BNA/GHF\_2102006

# RE: Beaches Link & Gore Hill Freeway Connection EIS application number SSI-8862 – Bike North Submission

**Phillip Hart** President Bike North 1 March 2021

Impacts on the active transport network within the Gore Hill Freeway and Artarmon area are shown in Figure 8-12.

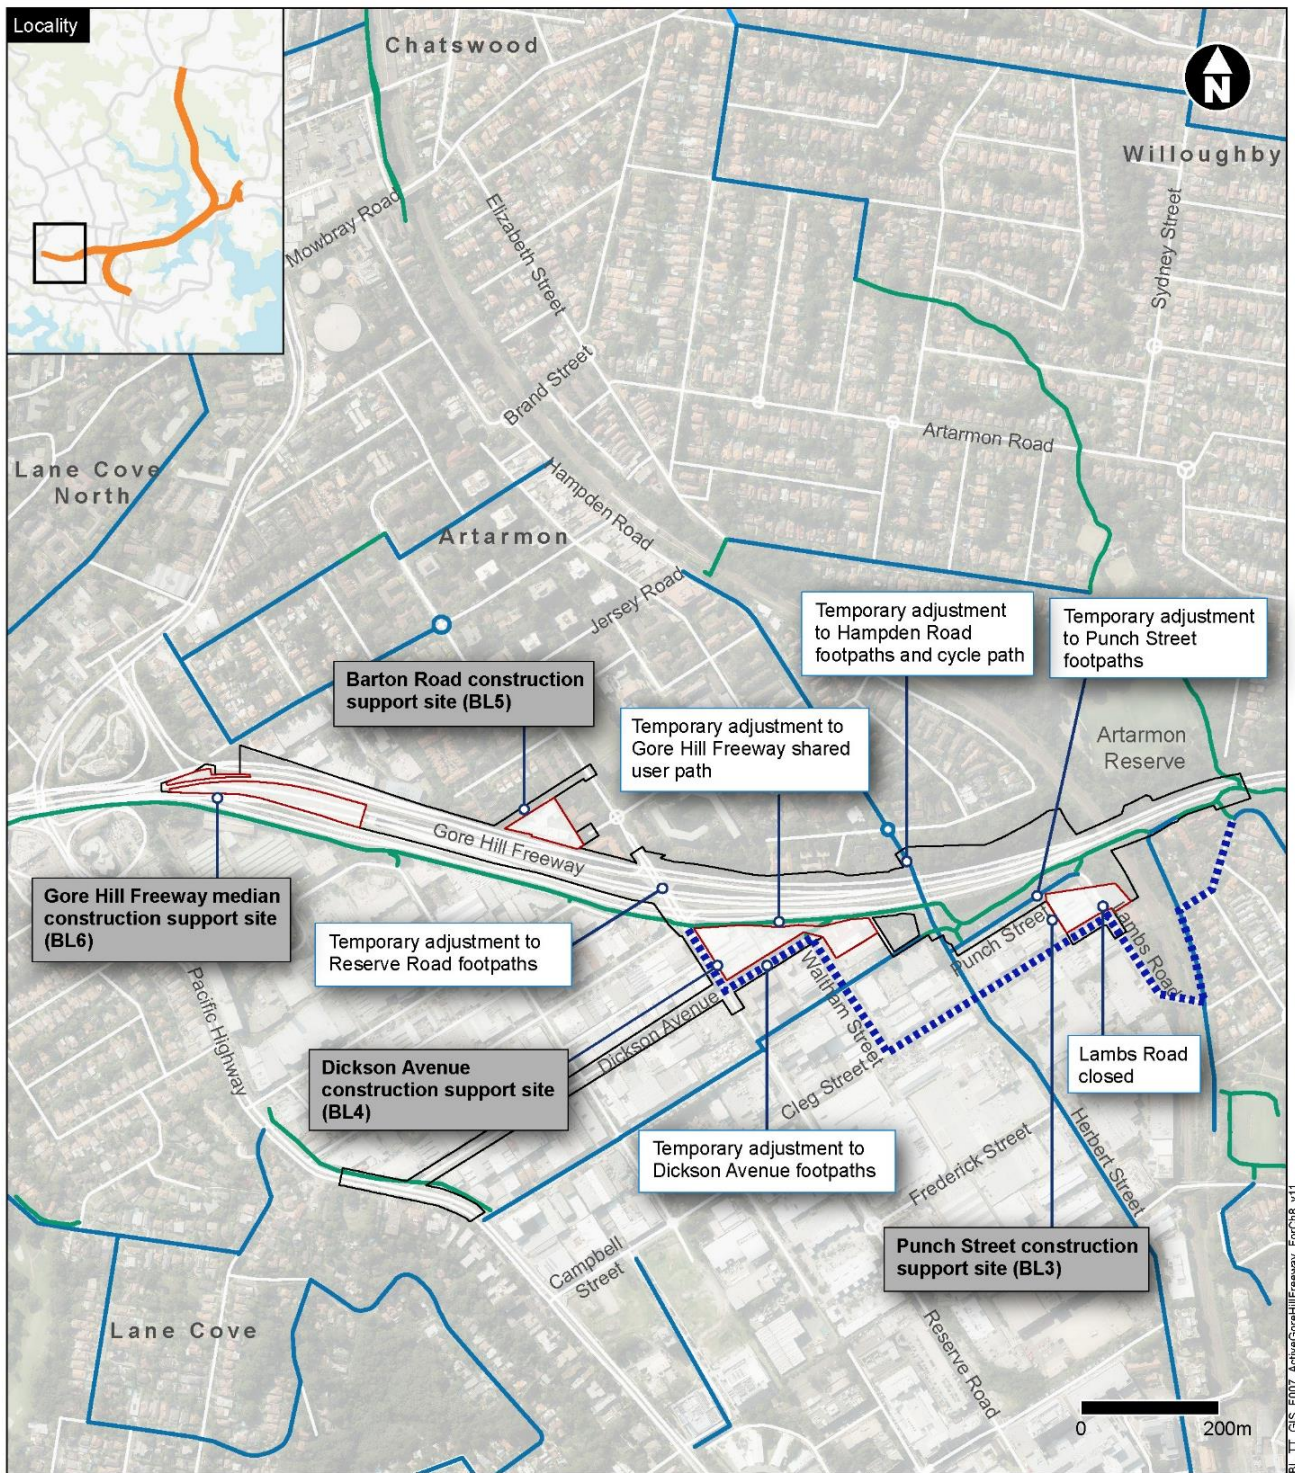
- 7. Bike North strongly objects to the severe impact during construction at the Artarmon Work Site to the high-quality cycleway alongside the Gore Hill Freeway by this proposal and the totally inadequate attention to provision of detour routes. Bike North requests that prior to any proposal approval, conditions be placed on this project to;

- continue the pathway along the existing alignment wherever possible. Bike North believe that the existing works, particularly the ancillary works, can be redesigned to minimise, and maybe avoid entirely, the need for a detour.

- Provide separation from vehicles, protection from heavy vehicles and to Austroads standards.
- Included as part of the overall site design, rather than fitting around a pre-determined site design.
- Be based on final designed path as much as practical.
- At all times be developed in consultation with Bike North with timely notification of any adjustments.
- Provide an underpass of the railway line preferably connecting to the existing path near Punch Street, so as to avoid steep hills and conflict with vehicles on and around railway overpass road
- Preferably provide an underpass of Herbert Street
- If detoured away from the cycleway, connect directly back to the path from Waltham Street to avoid Reserve Road

The Beaches Link EIS states that the cycleway along the Gore Hill Freeway will be within the proposed construction zone and that pedestrians and bike riders between Station Street, Naremburn and Reserve Road, Artarmon will therefore need to detour for at least the period of four years construction. The EIS document has identified a detour route for pedestrians and bike riders, through the hilly and highly trafficked Artarmon Industrial Area, even proposing a route along Reserve Road with its high volume of heavy vehicles and other roads which are access routes to the Beaches Link work sites.

The proposed four year detour route includes a hilly climb on local roads in Naremburn, difficult, unsafe manoeuvring into a significant tradie, vehicular route over the railway line at the Lambs Road Bridge, unsafe mixing with impatient drivers / heavy traffic along Lambs Road and Cleg Street, then extremely unsafe riding along up and downhill on major heavy vehicle Reserve Road. The EIS document itself is contradictory and lacking in detail. It describes and maps two different routes through the Artarmon Industrial Area. It proposes returning to the pathway at Reserve Road, when there is no existing access. Further questioning of the project team does not give us confidence that they have given the needs of pedestrians and bike riders any consideration in the development of the Beaches Link EIS.

Figure 9-6 Access arrangements upon completion of construction works at Gore Hill Freeway

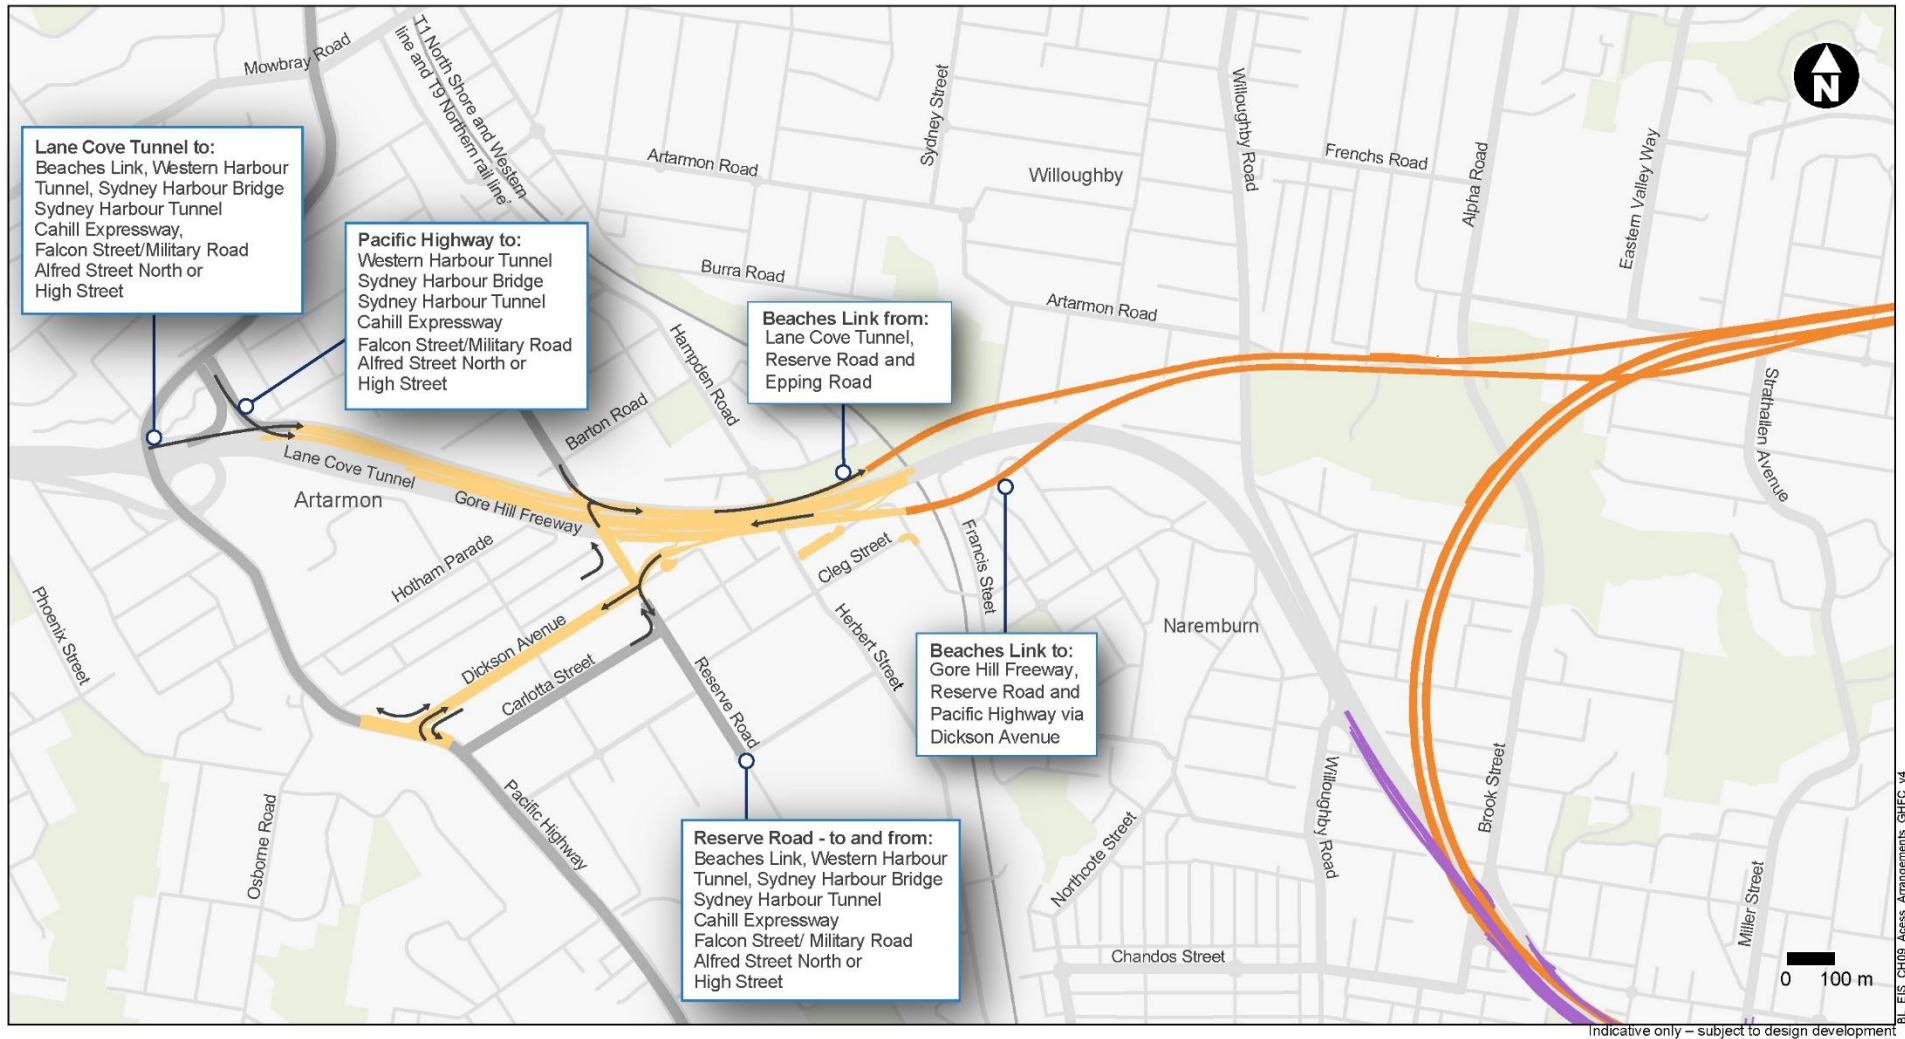
We also request that by the time construction is complete walkers and riders have returned to a continuous, connecting pathway at least to the current standard, with all railway and road underpasses and access routes of cycling facilities be minimised in impact. Such conditions should ensure that an equally safe, short, minimal time delay detour is provided for each cycling facility.
